Response to comments on the Noise Impact Assessment for the Station

Hotel, Hatton Peterhead dated 6 April 2023

APP/2022/2370

Date: 25/4/2023

Figure 1: Layout of SoundPLAN model showing outline of proposed pad, FLT route in red and receptors in yellow.

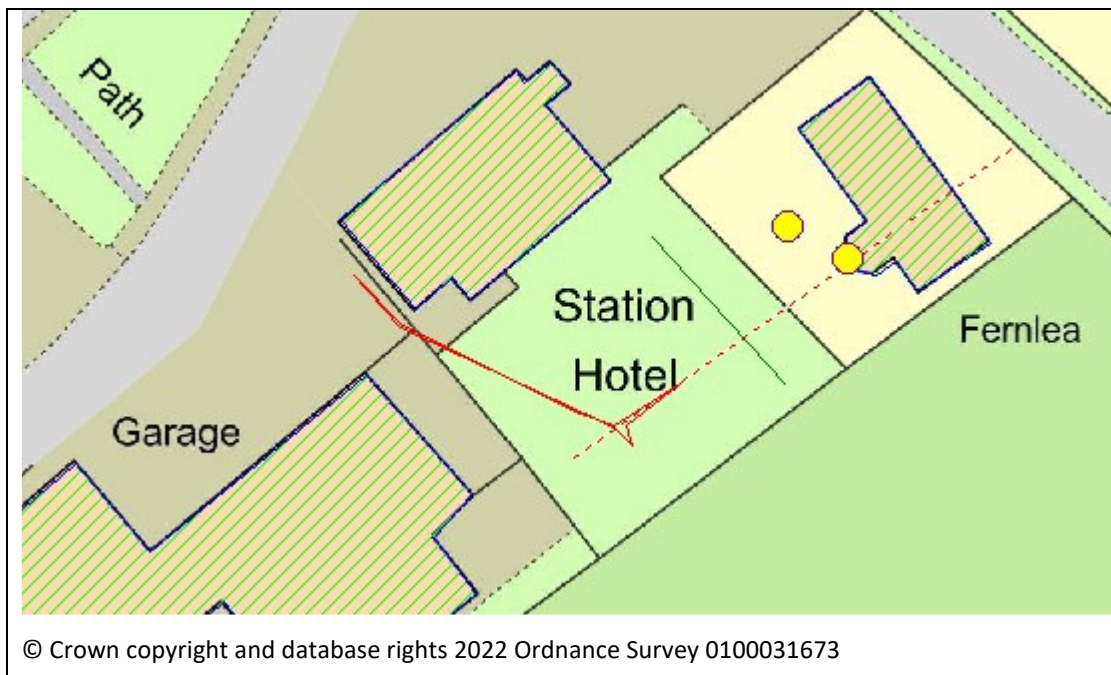
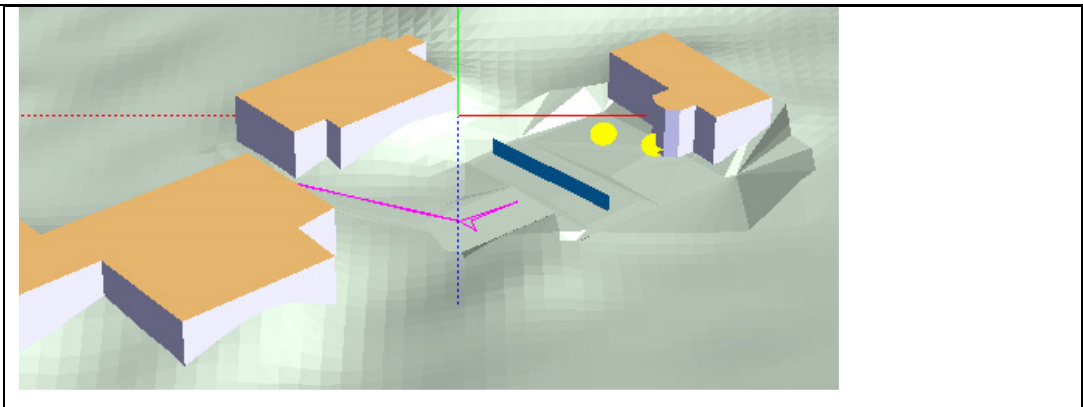
2. The information provided does not adequately reflect the ground levels at the receptor. The site sections show that the receptor ground level is substantially below the existing fence and proposed 2m acoustic barrier. However, from site visits the ground level at the receptor is higher than the existing fence and likely to be around the same level as the top of the acoustic barrier. Therefore, this may affect the insertion loss of the barrier and under predict the noise levels at the receptor. Updated site sections and NIA is requested showing the true site levels and noise levels at receptor.

The SoundPLAN model has been updated to use the ground heights in Table 1.
